# **STORMWATER MANAGEMENT PLAN FOR CLOVERLEAF SUBDIVISION**

**May, 2021**

El Paso County PCD File No.:  
SP-20-2

BMP PHASING

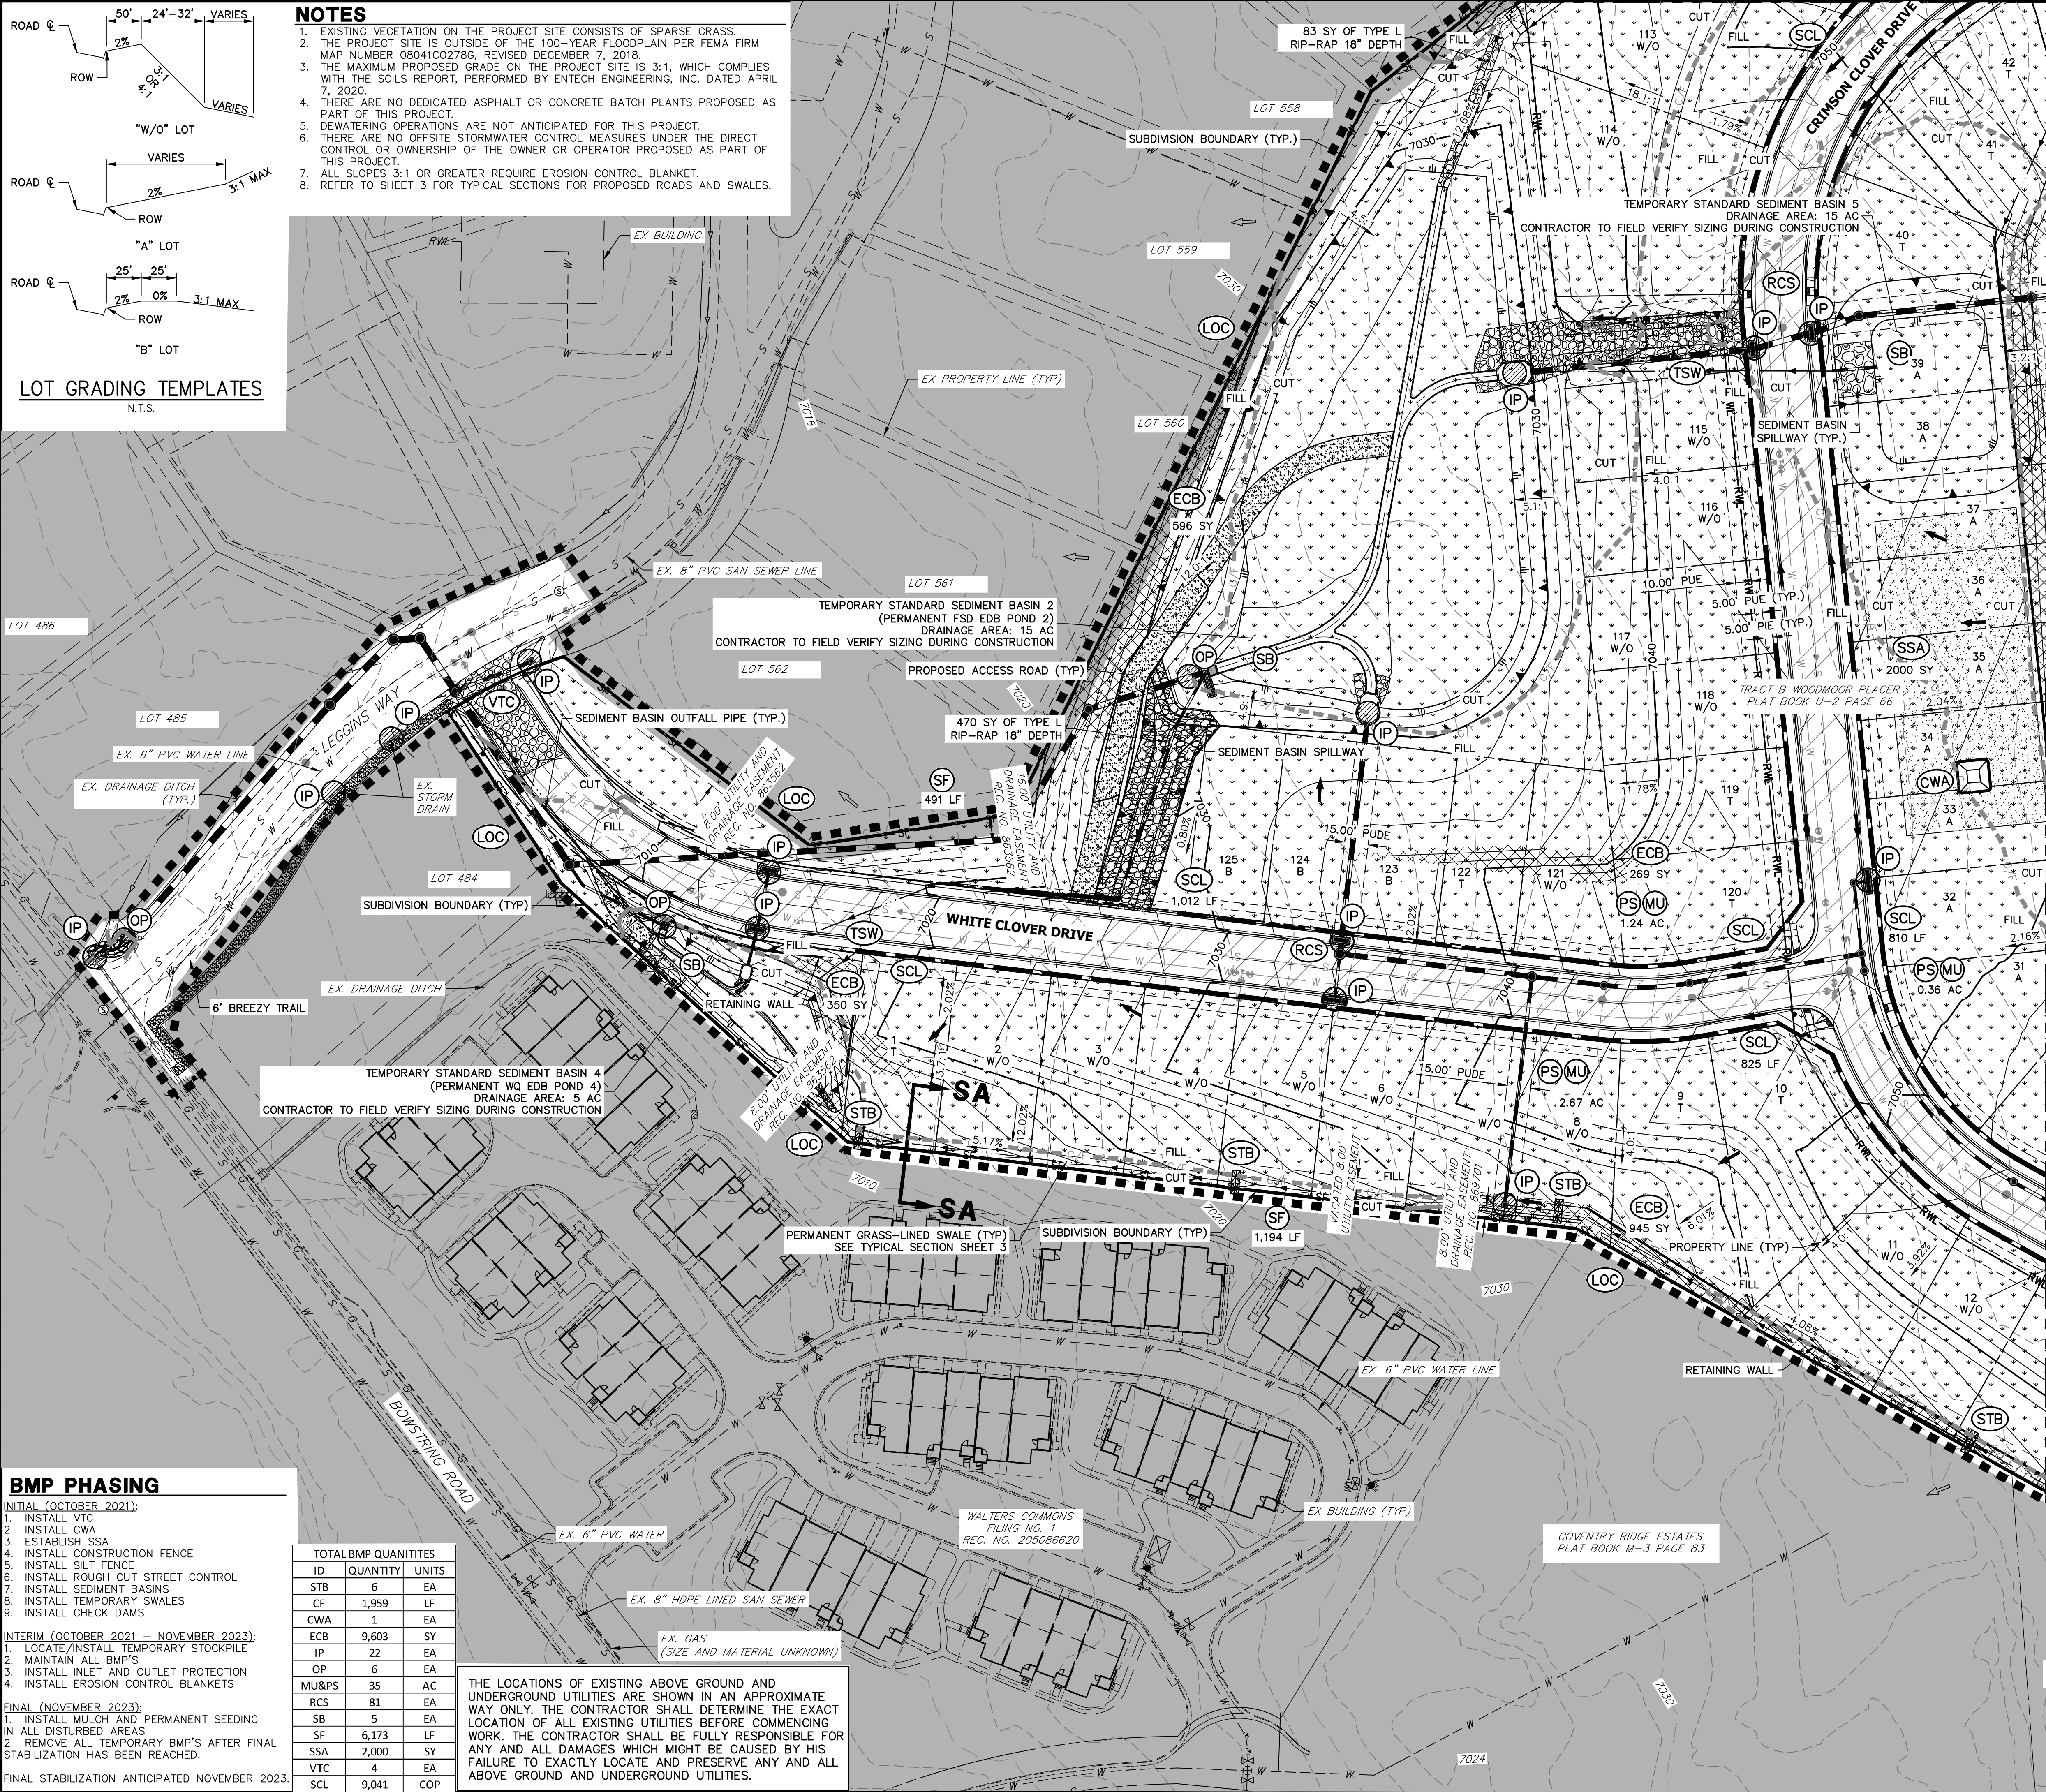
Checklist item 5 - Clearly define which construction tasks correspond to each phase of BMPs (initial, interim, and final) and/or phase of the project (pre-disturbance, site clearing, grading, etc) so it's clear when each BMP will be installed. See sheet 4 on GEC Plans.

JR - Labeled which tasks correspond with which phase of the BMP's
